<b>Application Reference Number:</b>	2026/0082
--------------------------------------	-----------

<b>Proposal Description:</b>	Erection of side detached double garage
------------------------------	---

<b>Location:</b>	14 Dale Green Road, Worsbrough, Barnsley, S70 5JX
------------------	---

Drawing No.	Rev No.
MGB001 -003	A

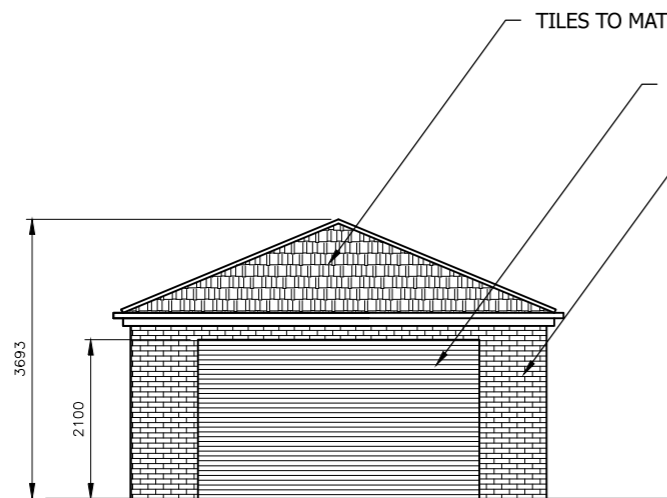
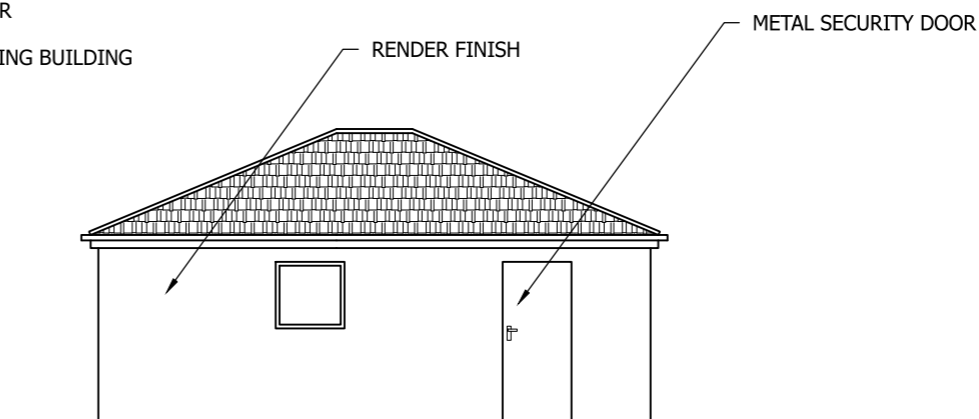
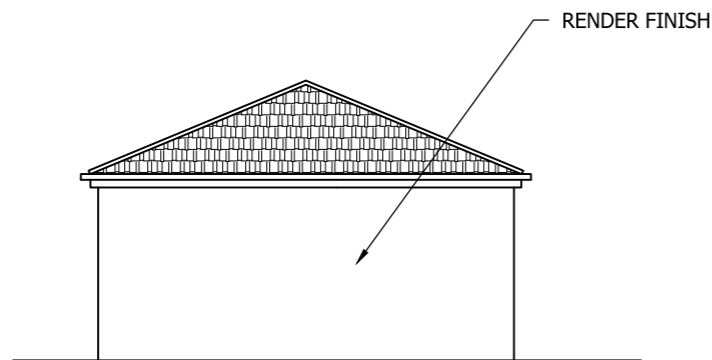
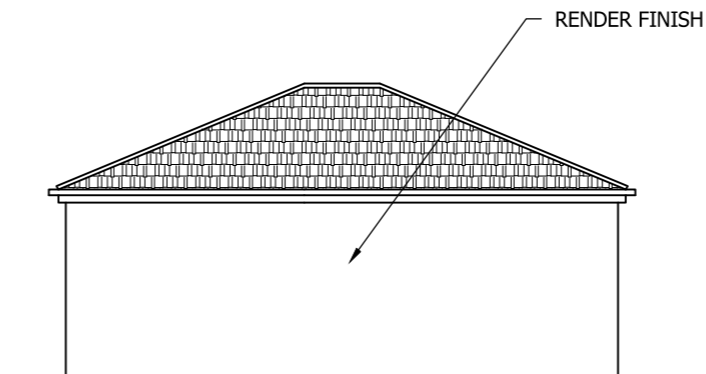
No objections were received from neighbouring properties. The SPD states that *“detached garages and outbuildings should be single storey structures and the eaves height should not normally exceed 2.5 metres from ground level, whilst the ridge height should not exceed 4 metres”*. The proposed garage has a hipped roof with an eaves height of 2.3 metres and a ridge height of 3.7 metres which is compliant with the above recommendation. This weighs significantly in favour of the proposal.

The SPD states that *“materials should normally be of the same type, colour and texture to the existing house or as close a match as possible”*. In this case, the proposed materials will be matching brickwork to three elevations and roof tiles with render proposed for the side elevation. There is no colour of render specified on either the plans however the choice of colour is of little consequence.

The introduction of render in the street scene would not be harmful in this circumstance as it would not be highly visible from public vantage points due to facing the host dwelling therefore reducing its prominence. The most visible sides of the garage would be brickwork. This weighs significantly in favour of the proposal.

Drawing No.	Rev No.
MGB001 -004	A

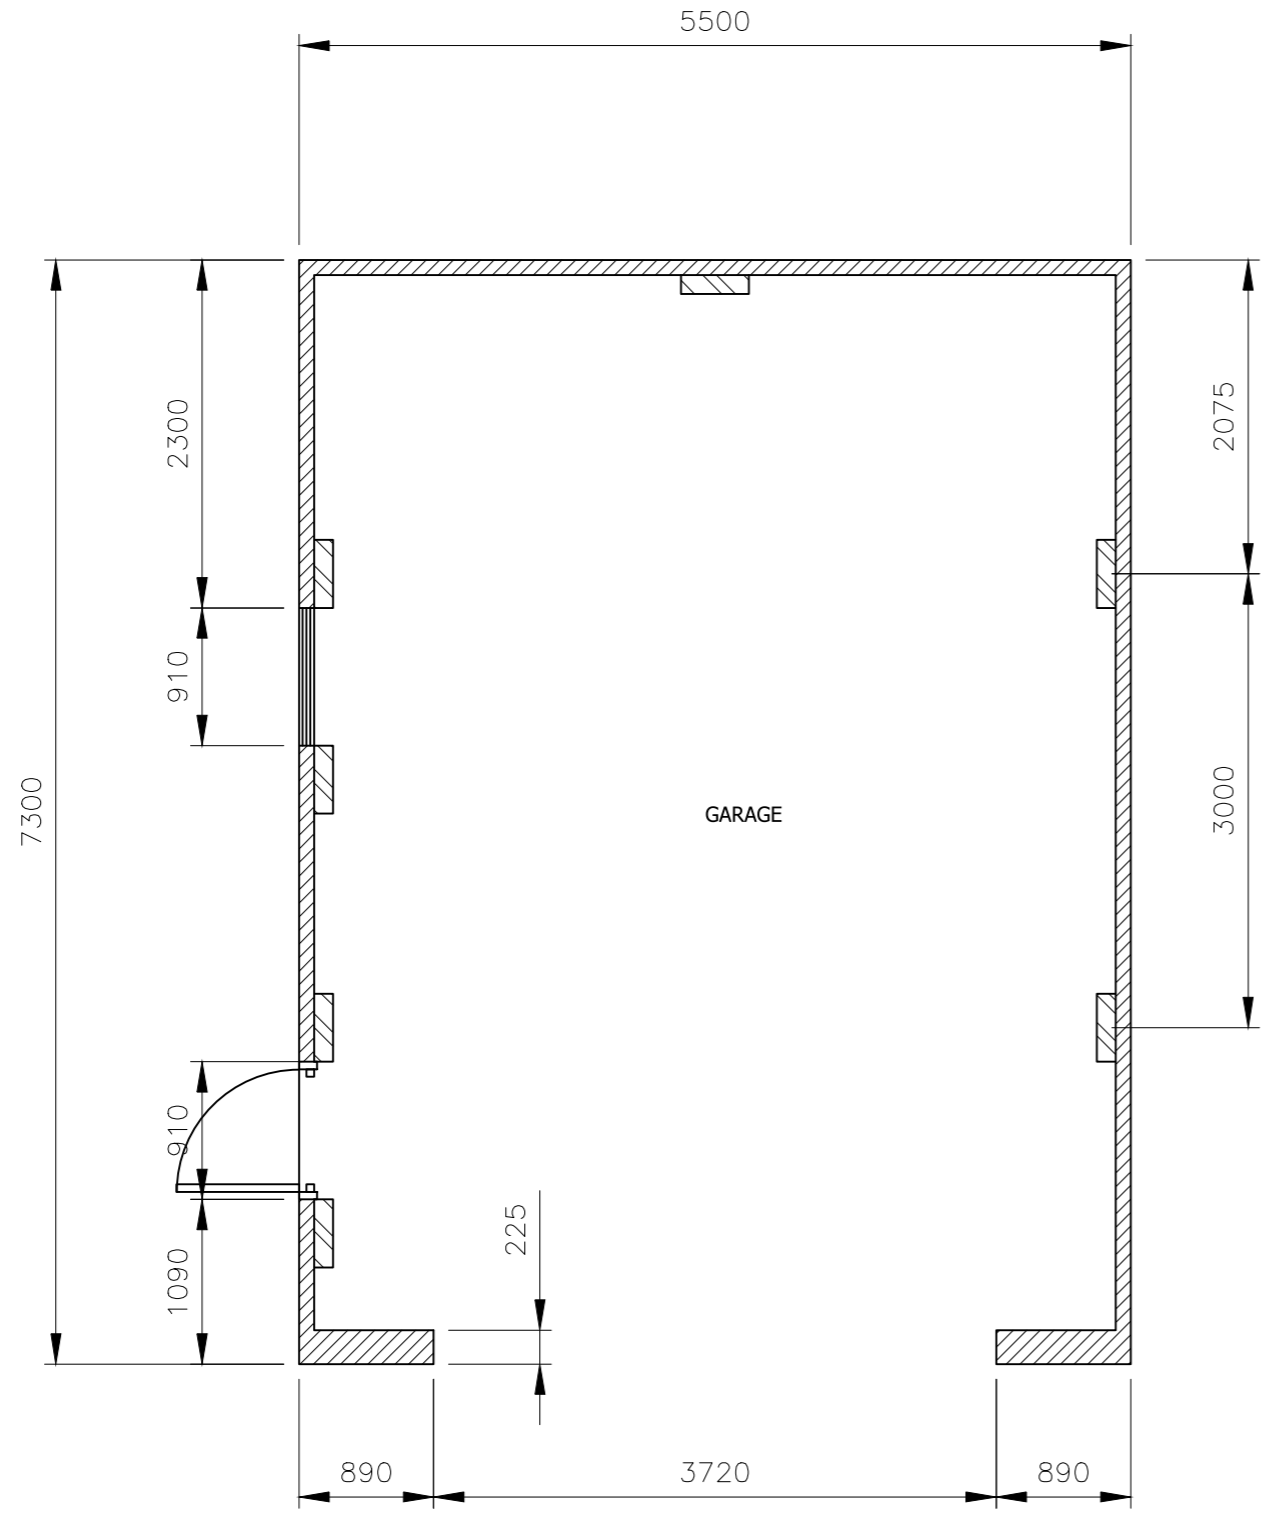
The SPD states that “proposals for garages will be assessed using the reference of a standard size for a single garage as outlined in the South Yorkshire Residential Design Guide, for double garage proposals a standard floor area size is considered to be 6.5m x 6.5m”. The proposed garage dimensions are in partial conflict with the SPD on this point measuring 7.3 metres by 5.5 metres, but only 37sqm internally, which is less than the maximum of 42sqm set out in the guidance. This weighs moderately in favour of the proposal.

There will be no significant detrimental impact on highway safety. The proposals don't alter the current access, and they would result in at least the same number of parking spaces within the site. The proposal would also introduce internal turning provision into the site which would be a benefit to highway safety. This weighs significantly in favour of the proposal.
